Immingham Green Energy Terminal

9.3 Applicant's Responses to the Examining Authority's First Written Questions

(Responses to "Q1.16. Cumulative Effects and In-
combination Effects")

Document Reference: TR030008/EXAM/9.3

FIGURE TITLE
Cumulative Assessment Short List - Sheet 2 of 2

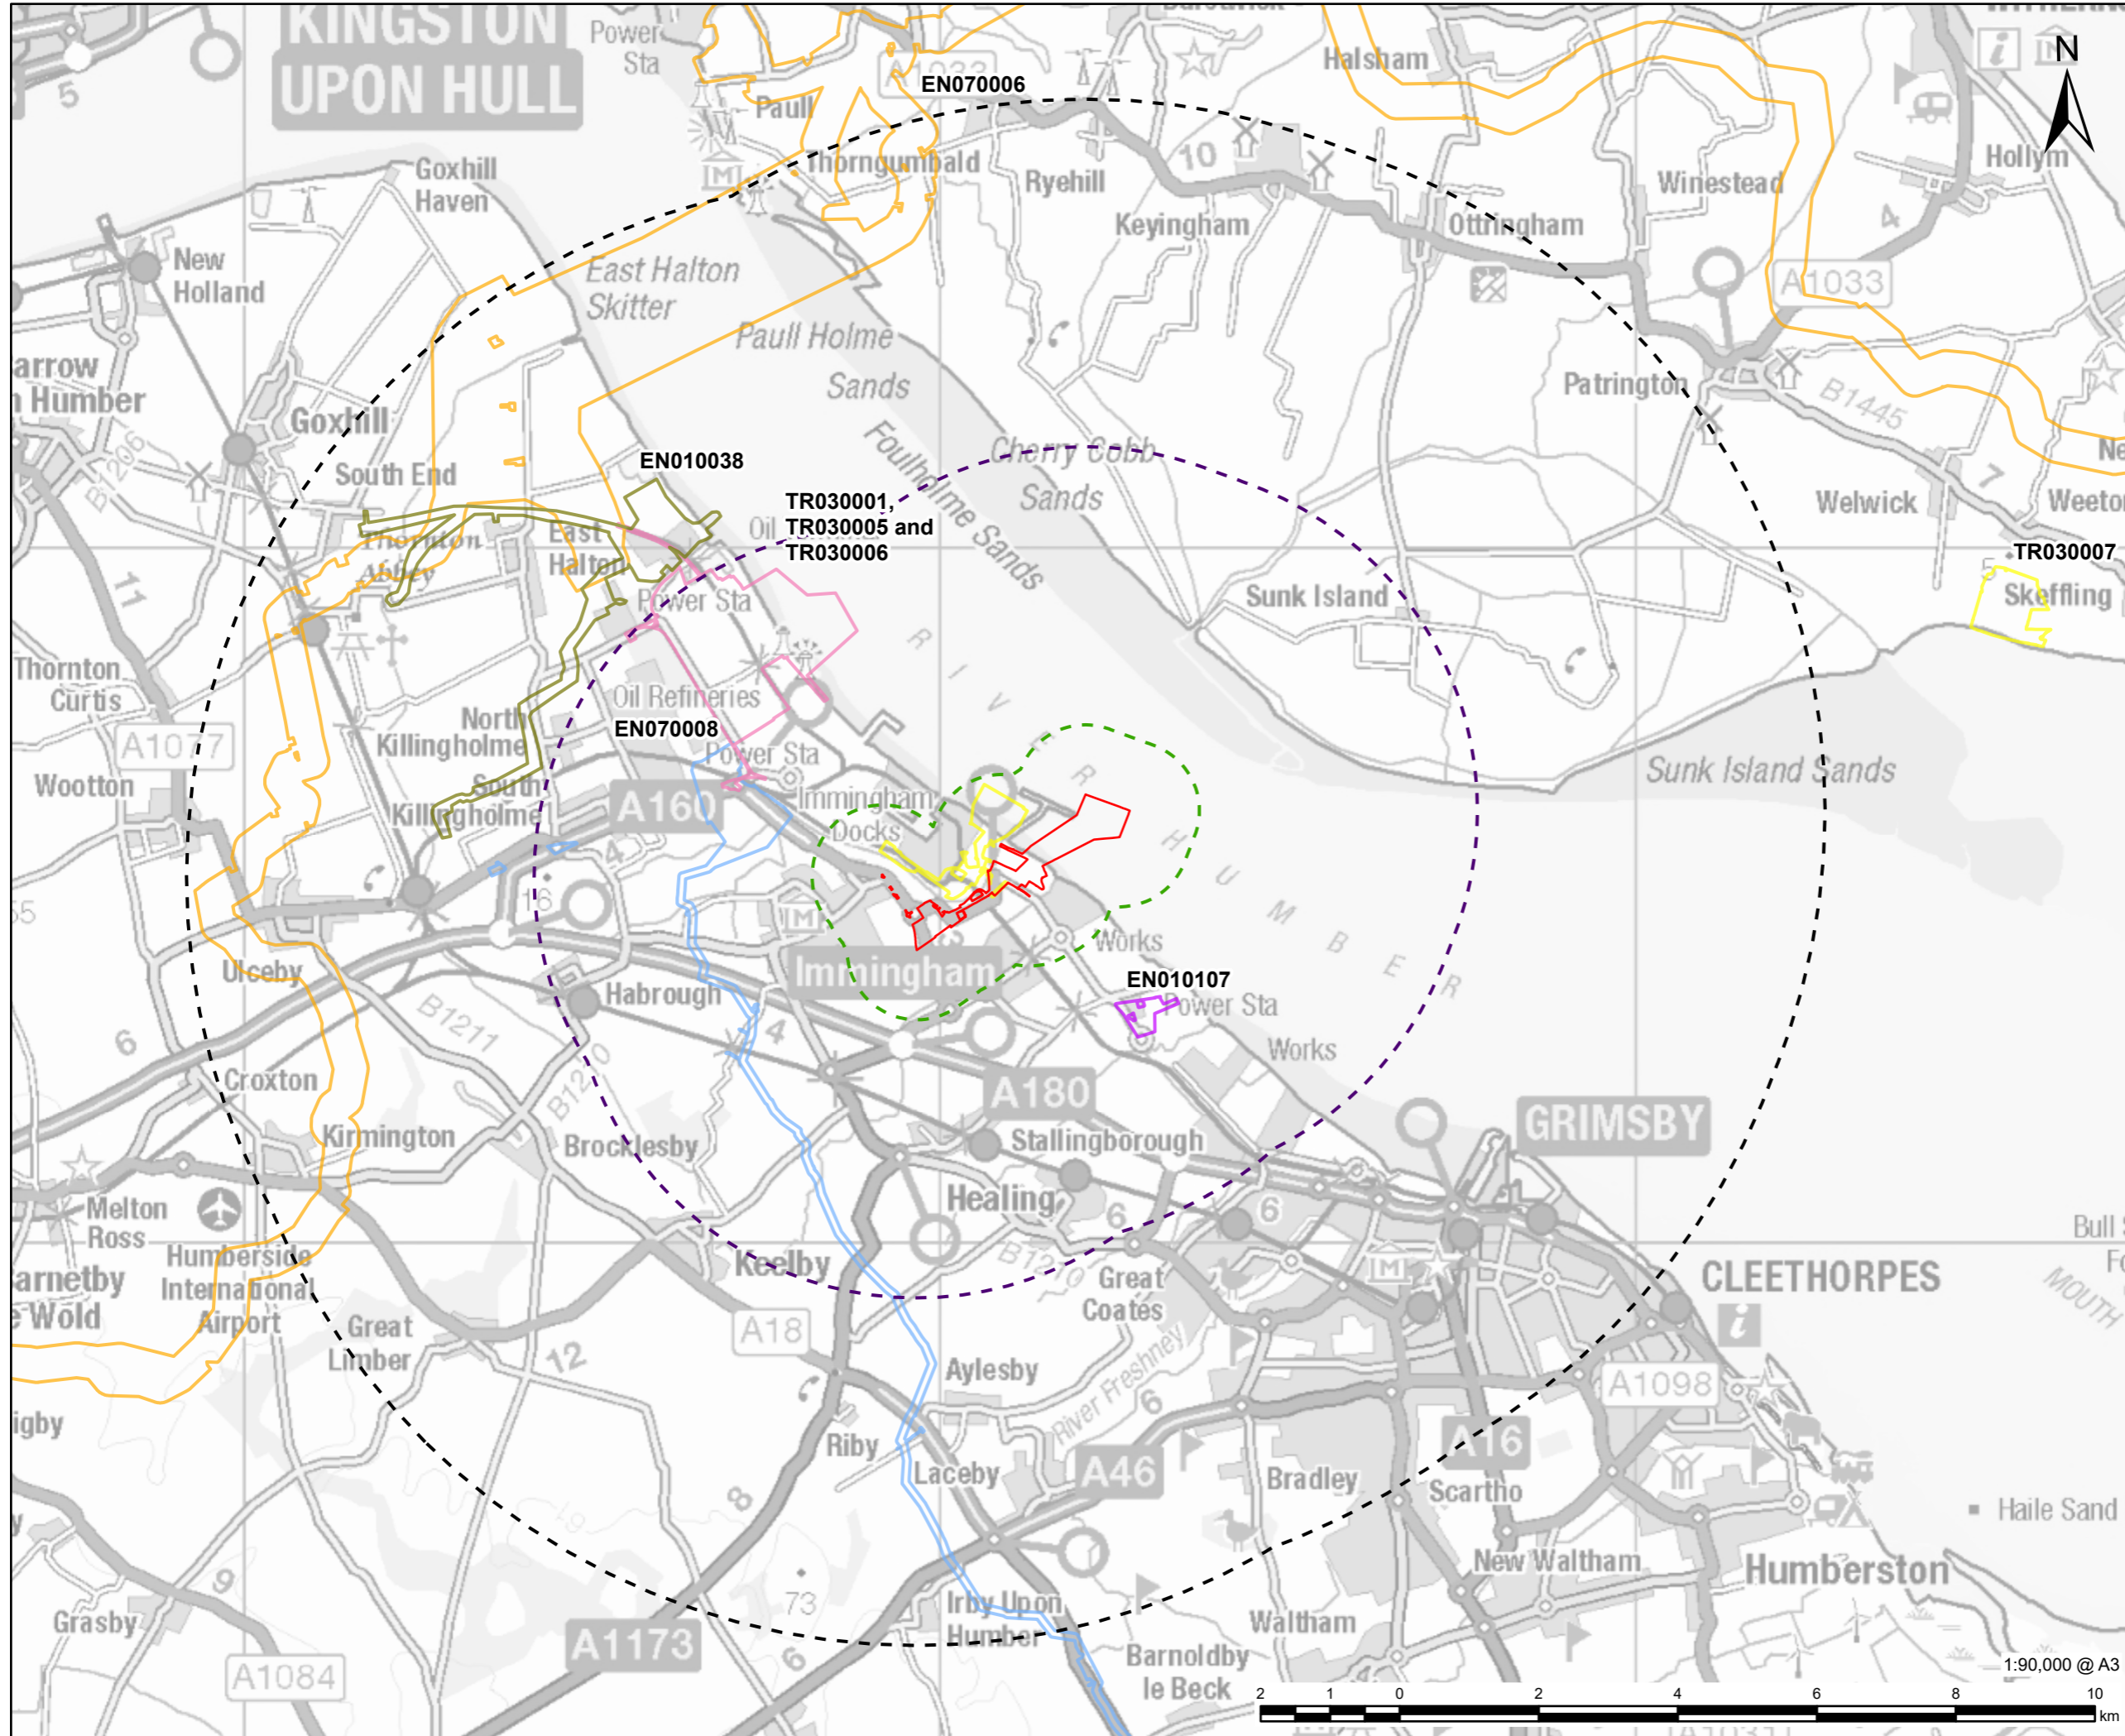
<p>Figure 25.2 Cumulative Assessment Short List</p> <p>Sheet 2 of Figure 25.2 [APP-166] appears to show an element of IERRT to be located on the northern side of the estuary. Clarify and submit an amended plan if necessary.</p>	<p>This polygon at Skeffling shown towards the eastern edge of Environmental Statement ("ES") Figure 25.2: Cumulative Assessment Short List [APP-166] originally formed part of the IERRT application boundary but was removed from those proposals.</p> <p>A replacement plan is provided as ES Figure 25.2 (2) [TR030008/APP/6.3 (2)], and as Appendix 1 of this document, and takes the opportunity to update in full the revised application boundary for the IERRT proposals.</p>
<p>Q1.16.2 Cross-cutting Questions</p>	
<p>Q1.16.2.1</p>	
<p>Question</p>	<p>Response</p>
<p>Advice Note 17</p> <p>In undertaking the in-combination and cumulative assessments, please confirm that the guidance contained in The Planning Inspectorate's Advice Note 17 has been followed. If not, please provide a justification as to why it was not.</p>	<p>As stated within Paragraph 25.4.1 of Environmental Statement Chapter 25: Cumulative and In-Combination Effects [APP-067]:</p> <p><i>"There is no standard method for assessing cumulative and in-combination effects, therefore the CEA has been undertaken on a qualitative basis using a combination of professional judgement, and the results of the individual assessments (presented in Chapters 6 - 24 [TR030008/APP/6.2]). In particular, the Planning Inspectorate's Advice Note 17 (Ref 25-4) has been used to inform the scope of the CEA and to assist with the identification of relevant developments to include."</i></p> <p>The Applicant confirms that the guidance provided within the Planning Inspectorate's Advice Note 17 has been followed and used to inform the scope of the cumulative effects assessment and to assist with the identification of relevant developments to include within the assessment.</p>
